Mr & Mrs R.E. Chisnall
28 Mansfield road,
Bognor Regis,
W. Sussex
PO22 9EY

Date: 13.12.2017

Reference: BR/305/17/HH

We wish to object to the proposed plans for two Dormer windows on the South Side of the Property.

PROPOSED ELEVATIONS

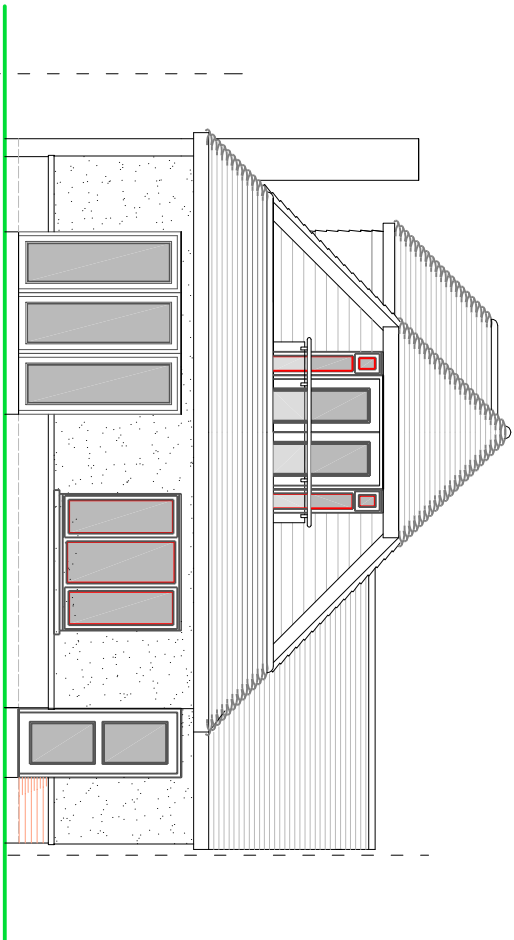
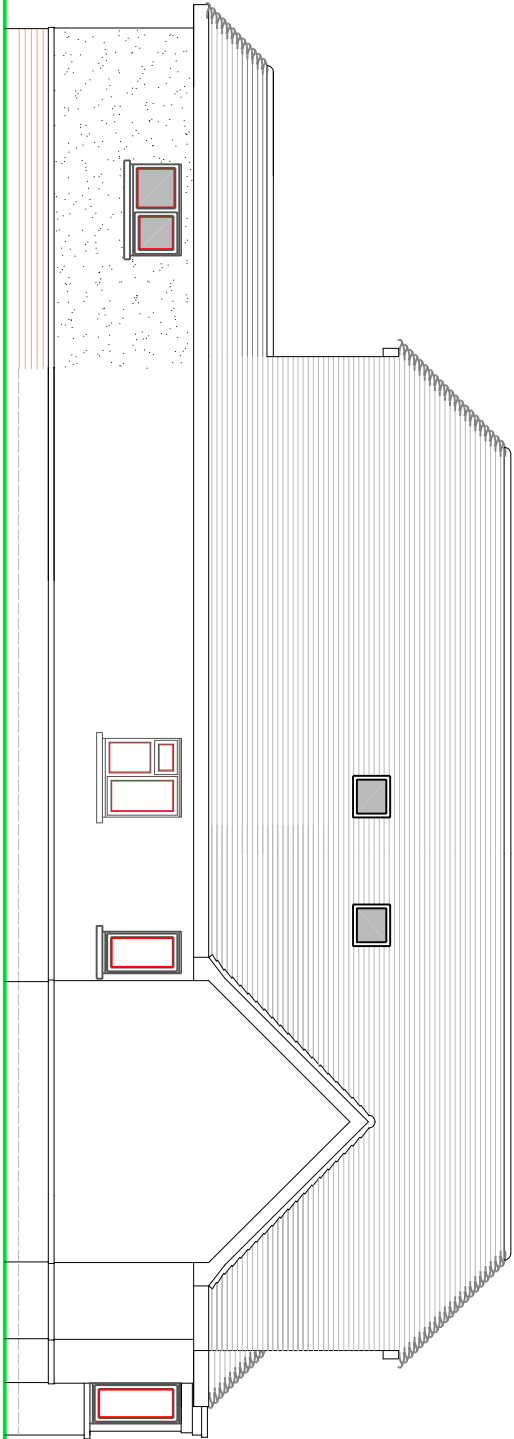
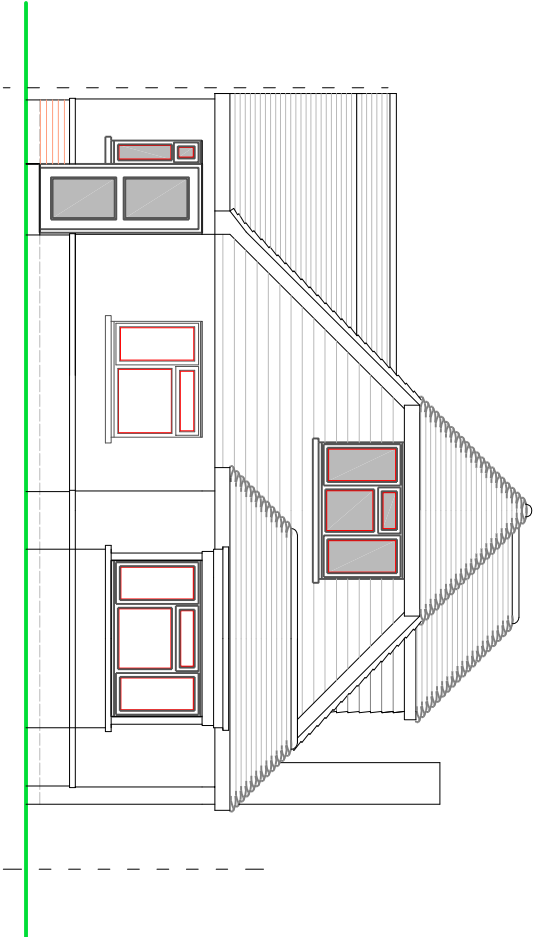
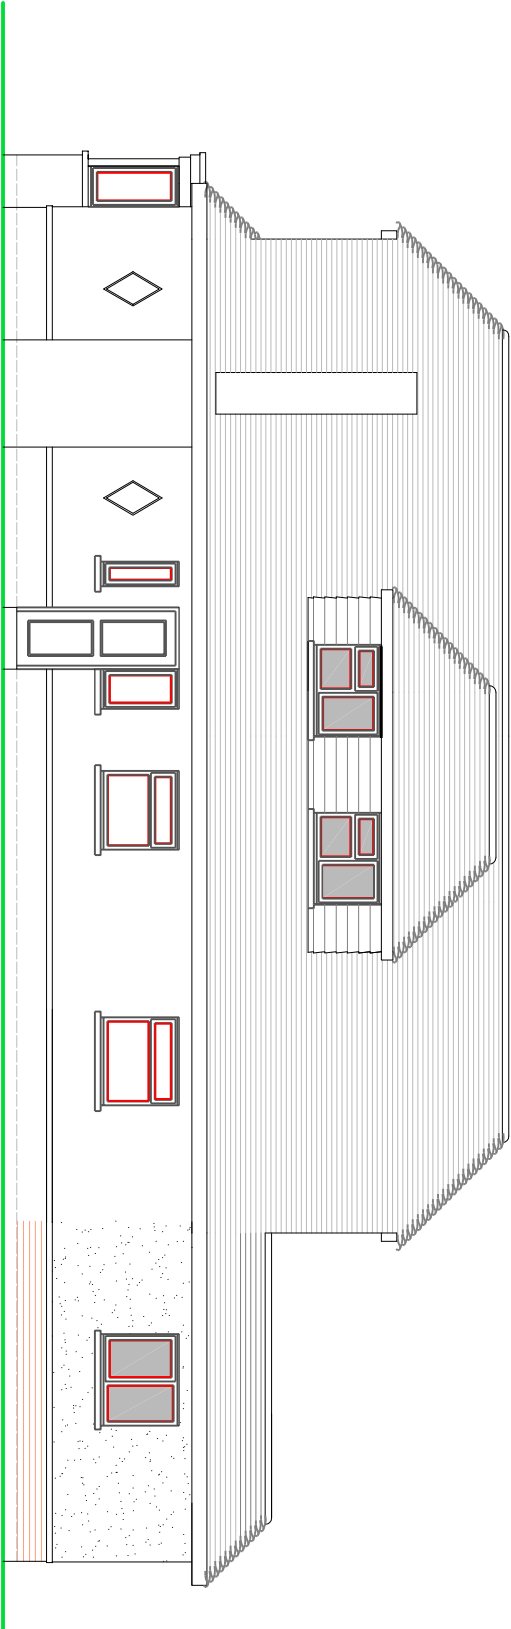
We strongly feel that the Dormer windows on the South side are also out of keeping to developments present in the streetscene and would therefore look out of place.

These two dormers on the South side are overlooking our property.

The works are extensive and alter the existing appearance & design of the bungalow in an adverse way.

We would not object to two Velux windows in place of the two dormers. 1.7 metres from the New Floor level to prevent over looking and a loss of privacy
